Application No: BE/59/21/PL  
Site Address: 339 Chichester Road Bersted PO21 5AN  
Description of works: Replacement of blockwork boundary wall with fence and new vehicular access (resubmission of BE/149/21/PL).

Thank you for your internet representation made on 7th May 2021 which has been recorded as an objection with the comments as follows:

SITE PLAN - SHOWING VISIBILITY SPLAYS
1:500 SCALE (at A3)

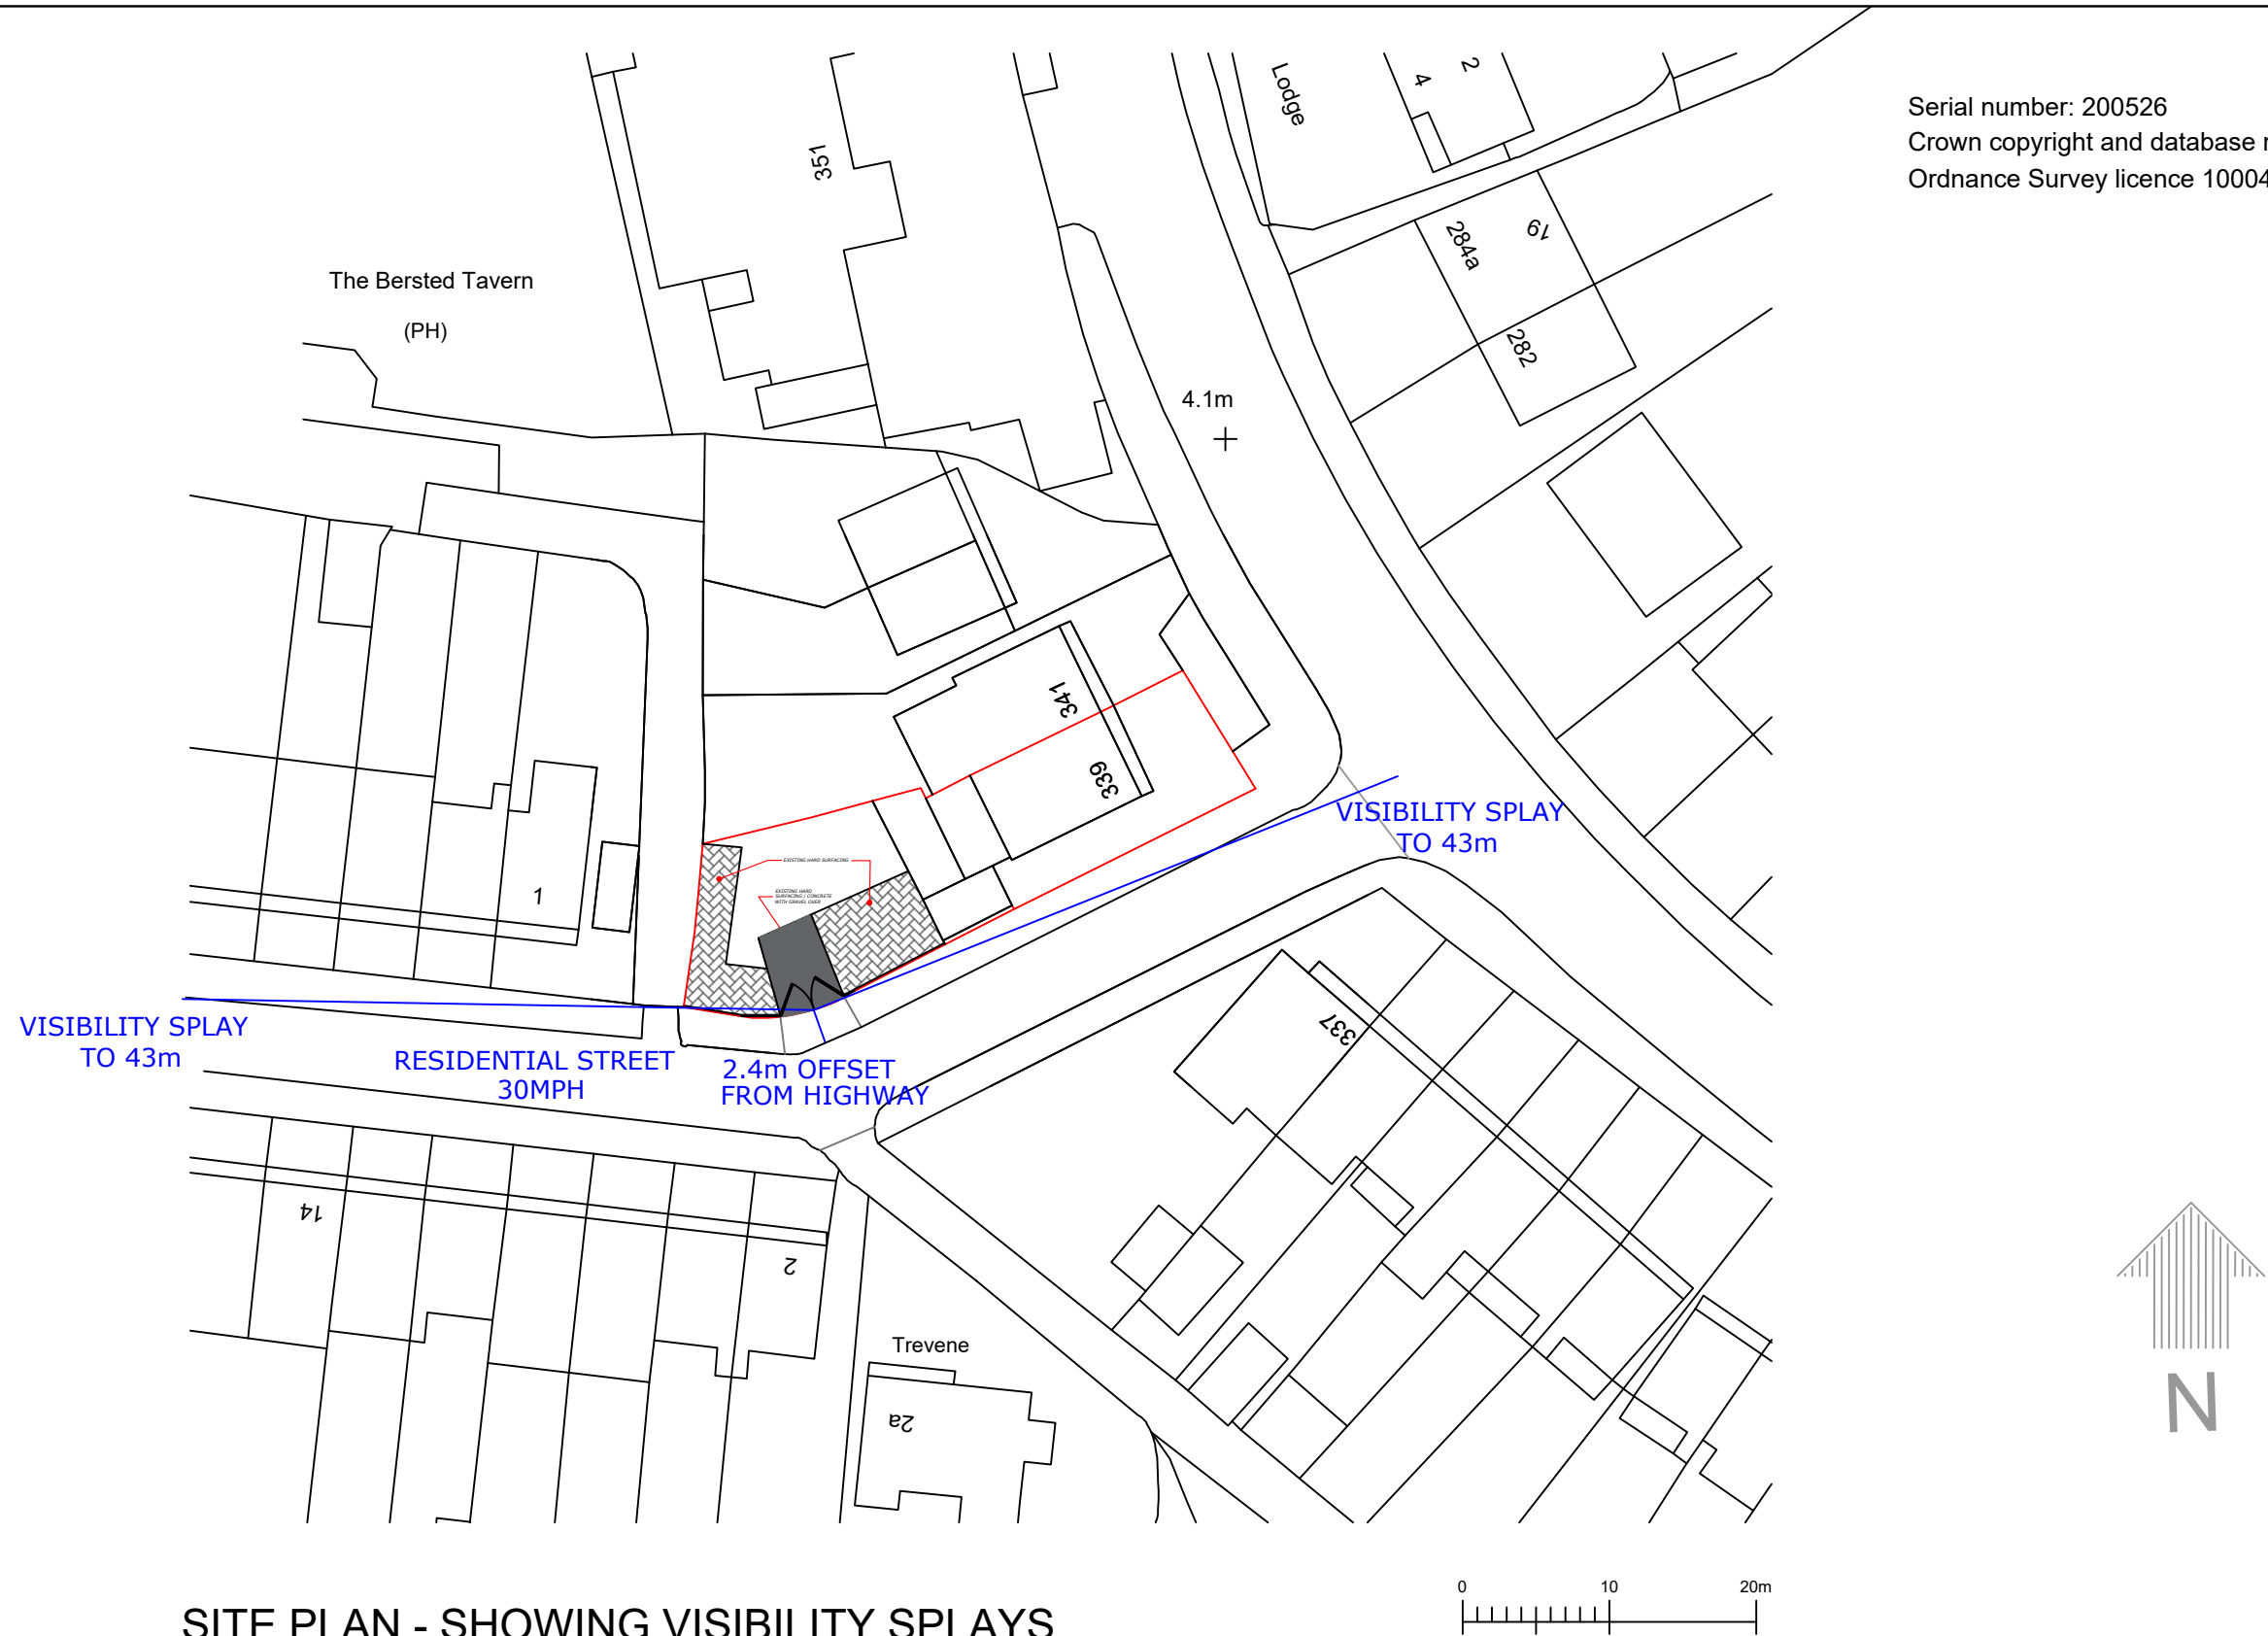
The lack of visibility due to the sighting of the proposed access on a bend would cause risk to pedestrians and other road users. Also the proposed entrance is opposite another junction. Bedford Avenue is a busy road at certain times of day and is used by pedestrians from local area to get to the Tesco Express. School children use lane opposite on foot and on bikes which is an additional risk. Bedford Avenue is used as a shortcut by motorists, sometimes at speed, when the B2259 is slow. For children who scoot on the pavement around the bend would not see or be prepared for a vehicle exiting from the side of this property where there has never been a drive before. The current fence around the property is too high for a vehicle to pull out safely onto the pavement. The property already has ample parking at the front which is never full. I can see no valid reason for this application to be granted with so many obvious risks to the public.
